COVER LETTER S51 ADVICE RESPONSE (MARCH 2023)

HyNet Carbon Dioxide Pipeline

Document Reference Number D.7.1.2

EN070007 HyNet Carbon Dioxide Pipeline – Further S51 Response

DRAWING TITLE  
**WORKS PLAN REGULATION 5(2)(i) APPLICATION DOCUMENT  
REFERENCE D.2.4 SHEET 8**

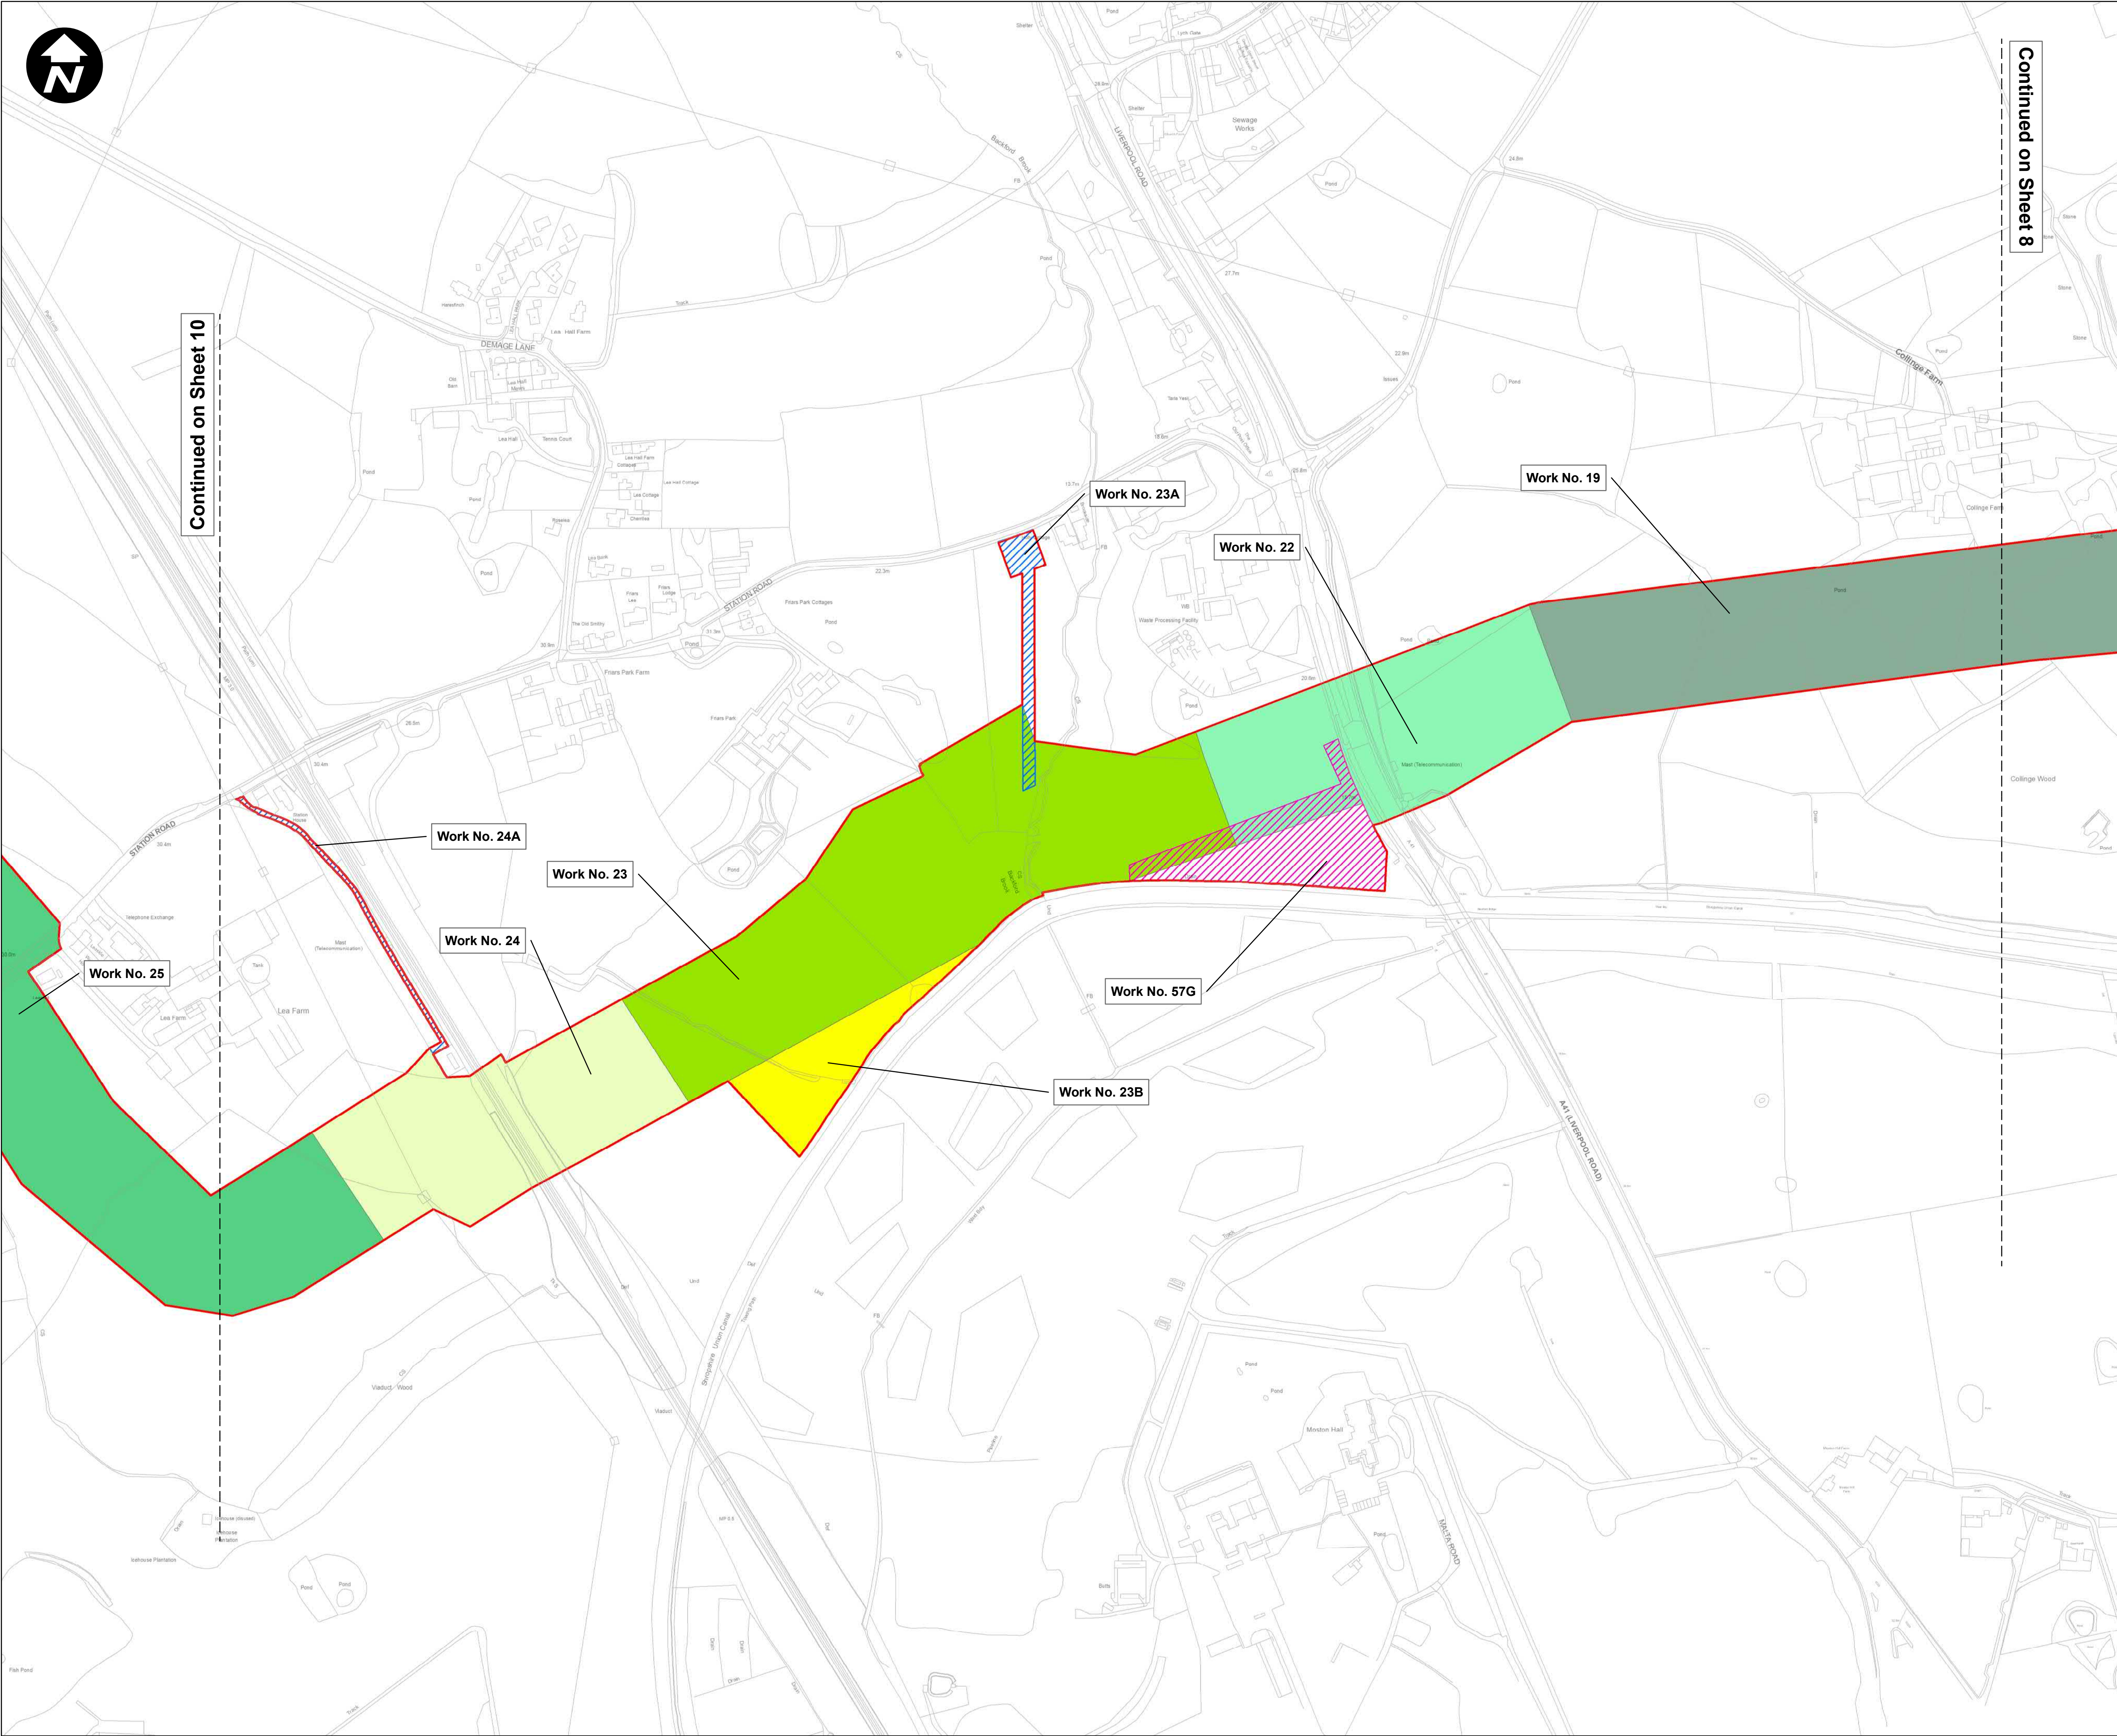
Application reference no.	Document Name	Sheet no.	Nature of Change	Reason For Change
		Sheet 7	Addition of Work No. 17A and 17B to highlight new permanent access points	Post-Acceptance Errata
		Sheet 8	Work No. 19C changed from Permanent Access to Temporary Access	Post-Acceptance Errata
		Sheet 9	Hatching for Work No. 24A reduced to fall within order limits to correct digitisation issue	Post-Acceptance Errata
		Sheet 10	Work No. 25A changed from Temporary Access to Permanent Access	Post-Acceptance Errata
		Sheet 10	Removal of white space to the north of Work No. 25 (sheet 10) by reducing the order limits to ensure that the property is not impacted by the DCO.	Post-Acceptance Errata
		Sheet 12	Addition of English/Welsh border in the key of sheet number 12.	Post-Acceptance Errata
